<b>Urban Design Response</b>			<b>Officer:</b>	<b>Stephen Kilmartin</b>
<b>Description:</b>	Land off Chatburn Old Road			 <b>Ribble Valley Borough Council</b> <a href="http://www.ribblevalley.gov.uk">www.ribblevalley.gov.uk</a>
<b>Application Ref:</b>	2014/0618	<b>Case Officer:</b>	S.W	
<b>Response Ref:</b>	2014/0618/UDR/01	<b>Consult Date:</b>	25/07/14	
<b>Meeting Date:</b>	N/A	<b>Issue Date:</b>	08/09/14	
<b>OFFICER REFERENCE ONLY</b>

Proposed Location Plan - 1:1250

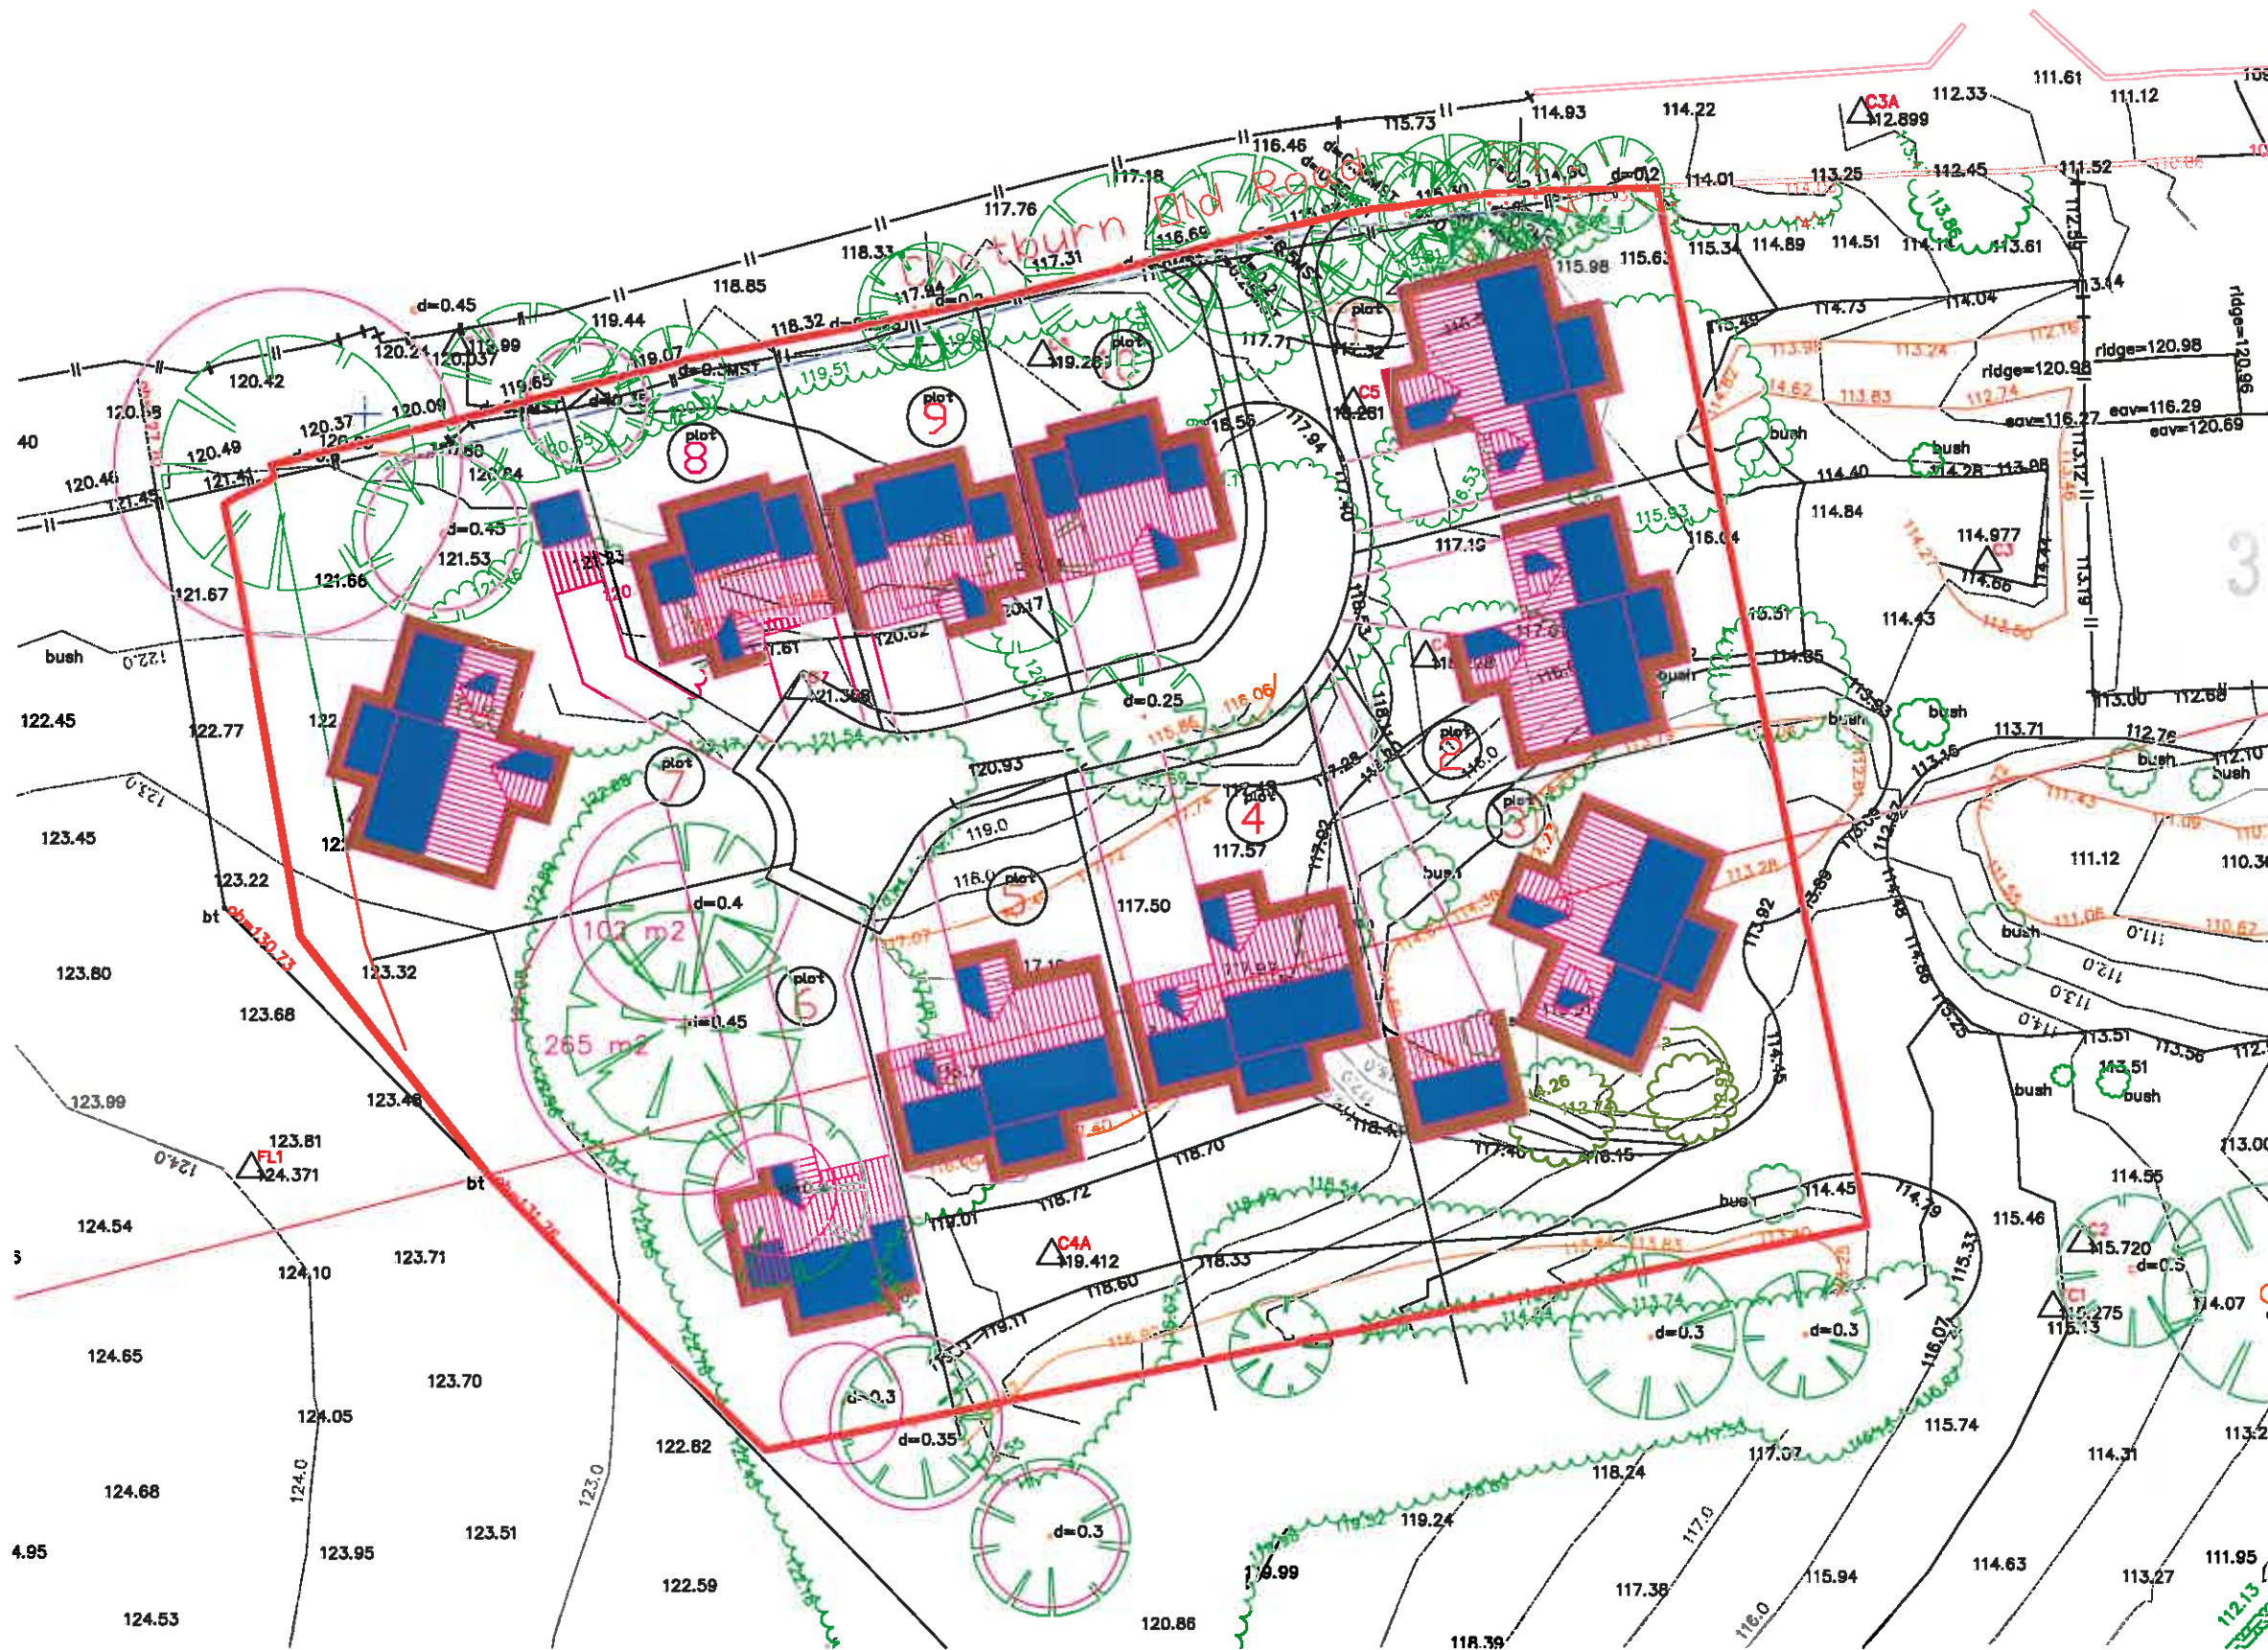
<b>General Comments/Observations</b>	
<b>1.1</b>	It is noted that the proposed layout presents rear elevations and rear yards to the frontage of Chatburn Old Road, this is at odd with the remainder of the properties to the east. The layout appears to take the form of a 'suburban' cul-de-sac which is significantly detached from the main settlement and fails to respond to the inherent plan form and grain of the settlement resulting in a discordant form of development.
<b>1.2</b>	Given the topography of the site plot 01 is likely to be afforded a high level of visibility upon approach, it is my opinion that the orientation of the plot and the side-on arrangement to Chatburn Old Road will emphasise the discordant relationship with the existing dwellings to the east as mentioned above.
<b>1.3</b>	The proposed sections/streetscenes, in particular Section 03 fails to accurately reflect the overall form of the house-types proposed for plots 08 -10, I have also noted that a number of the ridge heights do not correspond.
